Your ref:
Our ref: 22/00345/F
Please ask for: Miss Sandra Homcenko
Direct dial: 01553 616824
E-mail: borough.planning@west-norfolk.gov.uk

Details: **Proposed Replacement Dwelling and Garage (Self-Build) at Holkham View 115
Burnham Road North Creake Norfolk NR21 9LB**

I have received a planning application as detailed above but cannot process it until I receive some more information:

Previous Side Elevation 1:100

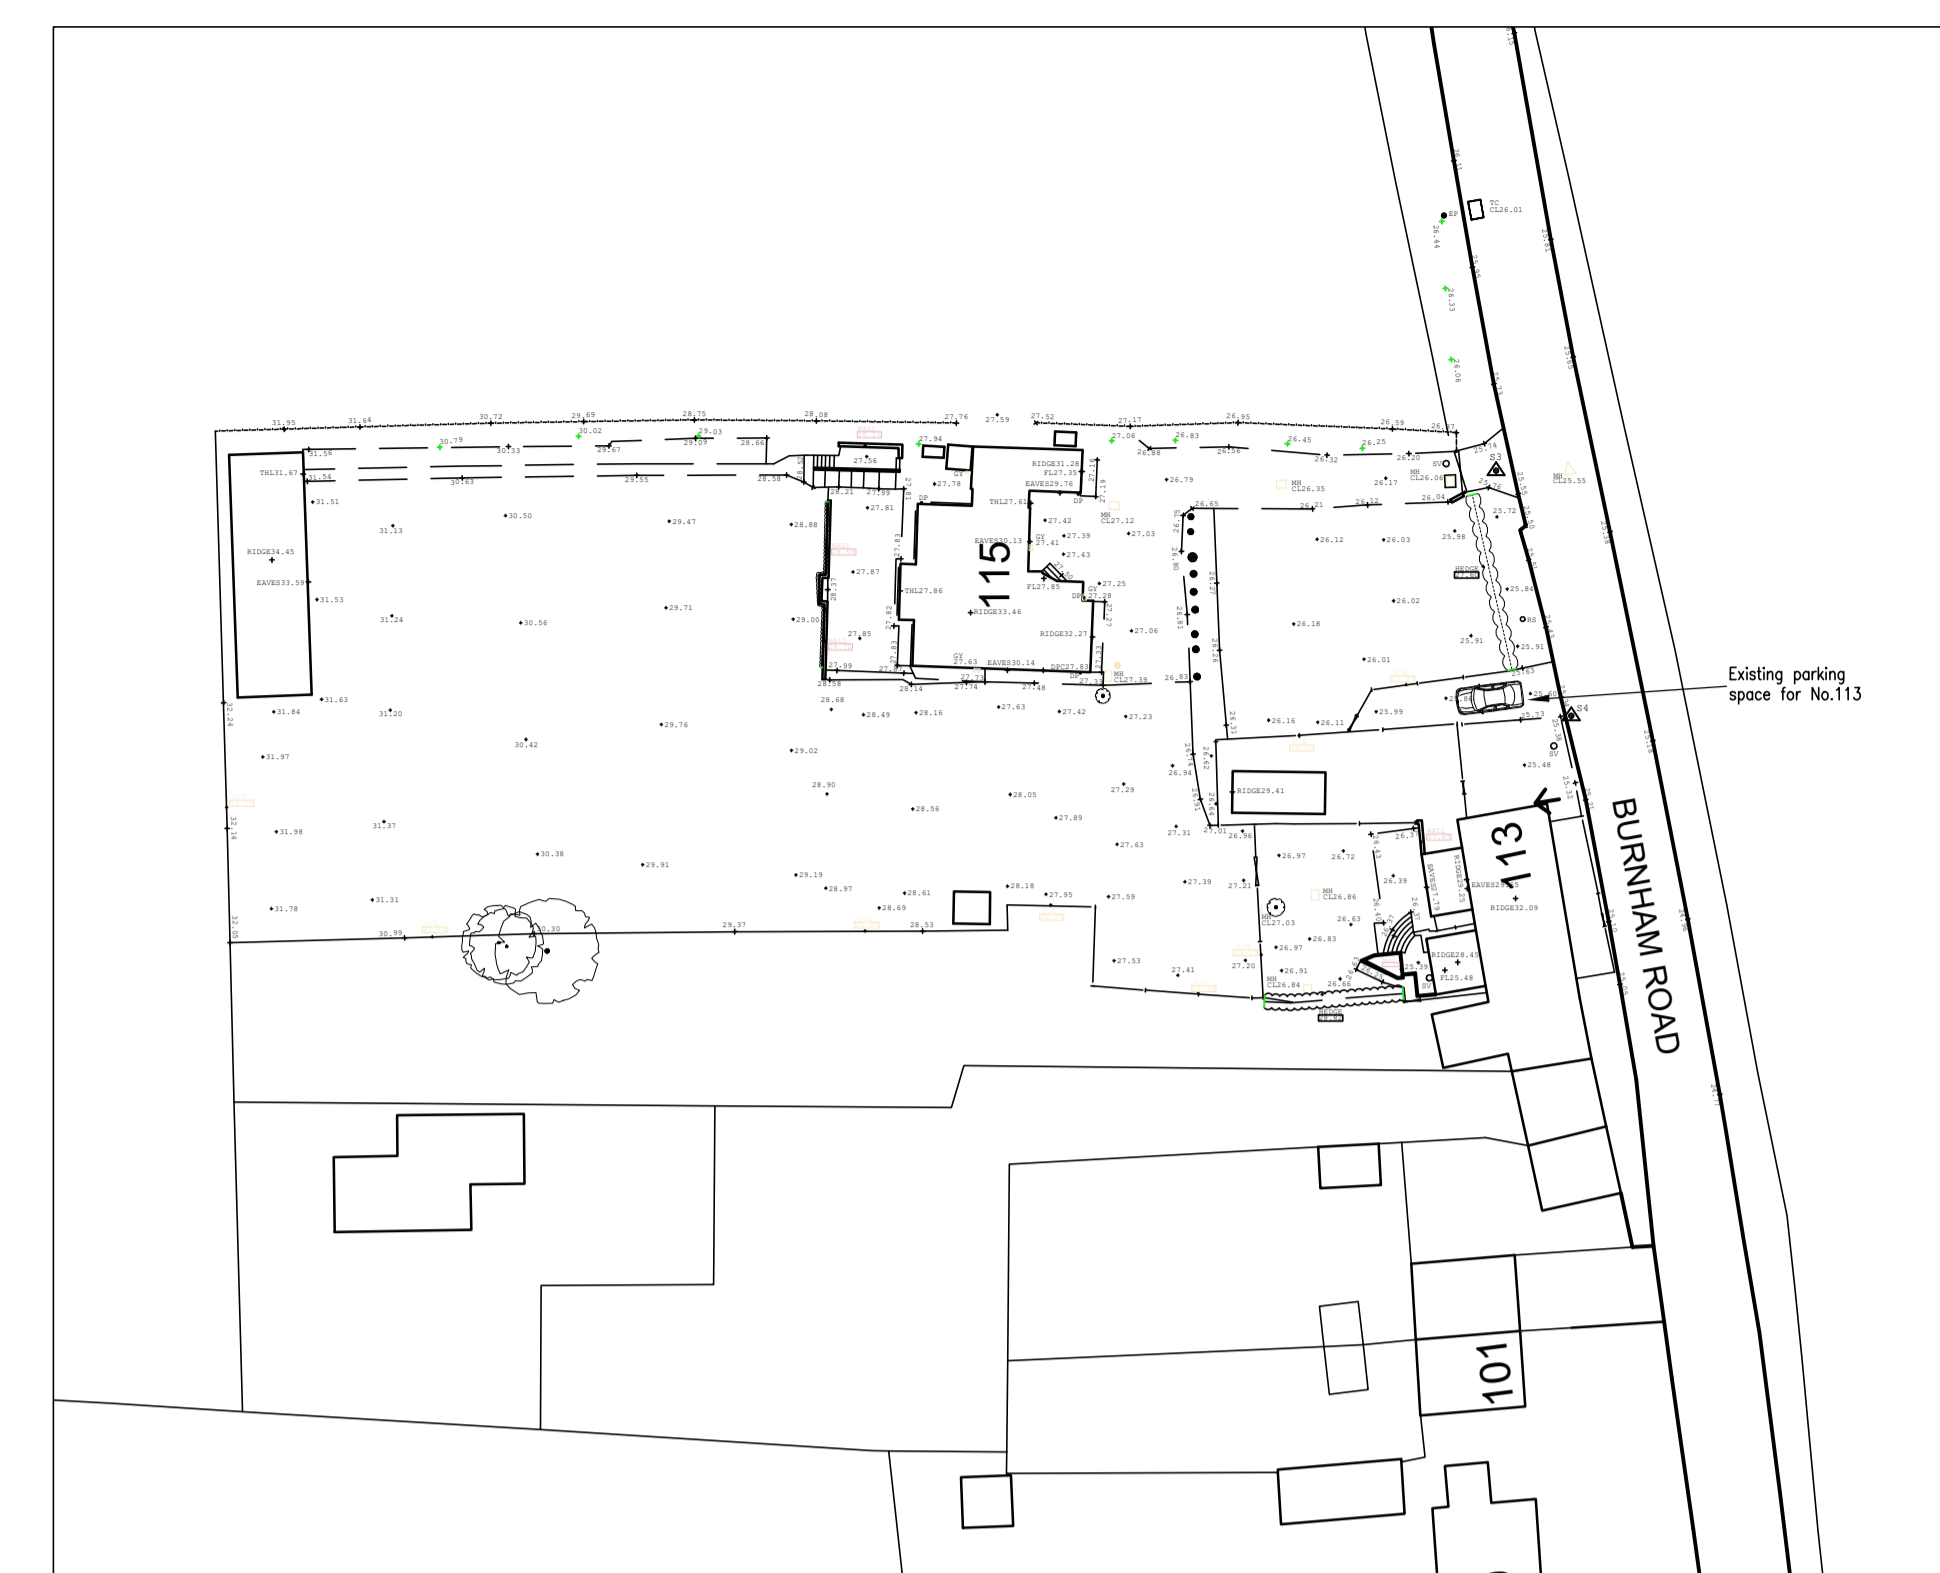
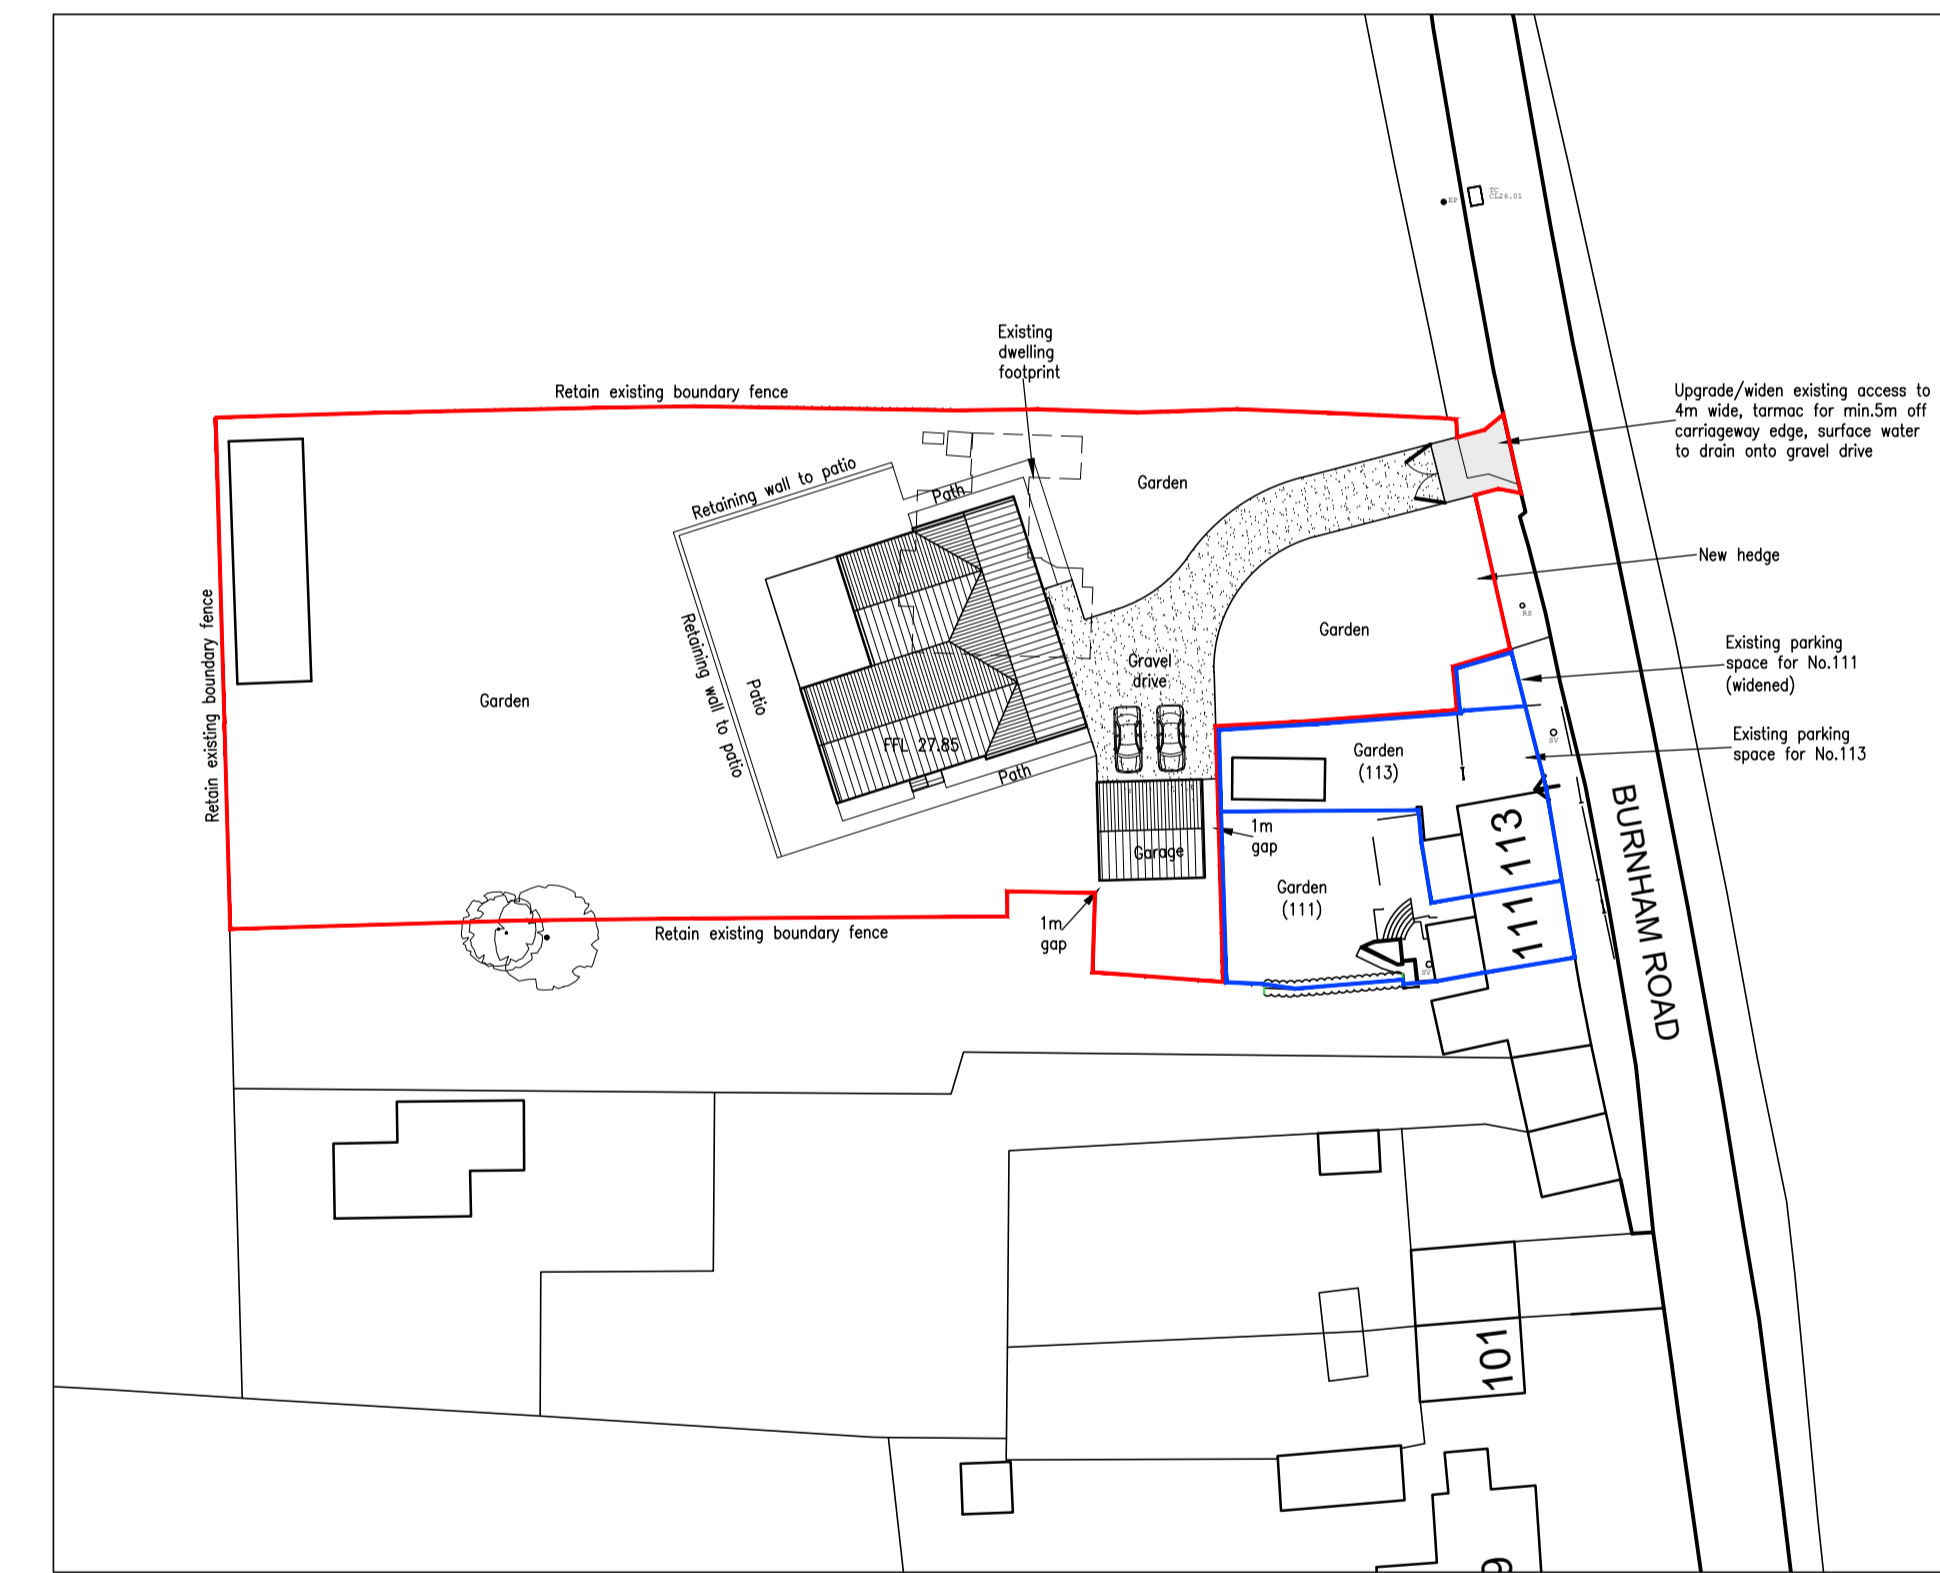
1. Please confirm what are you trying to show with "Previous Side Elevations"?
2. Please provide drawings to a recognisable scale, showing existing and proposed site levels. If the site levels are to remain unchanged, please provide the drawings annotated as existing and proposed.
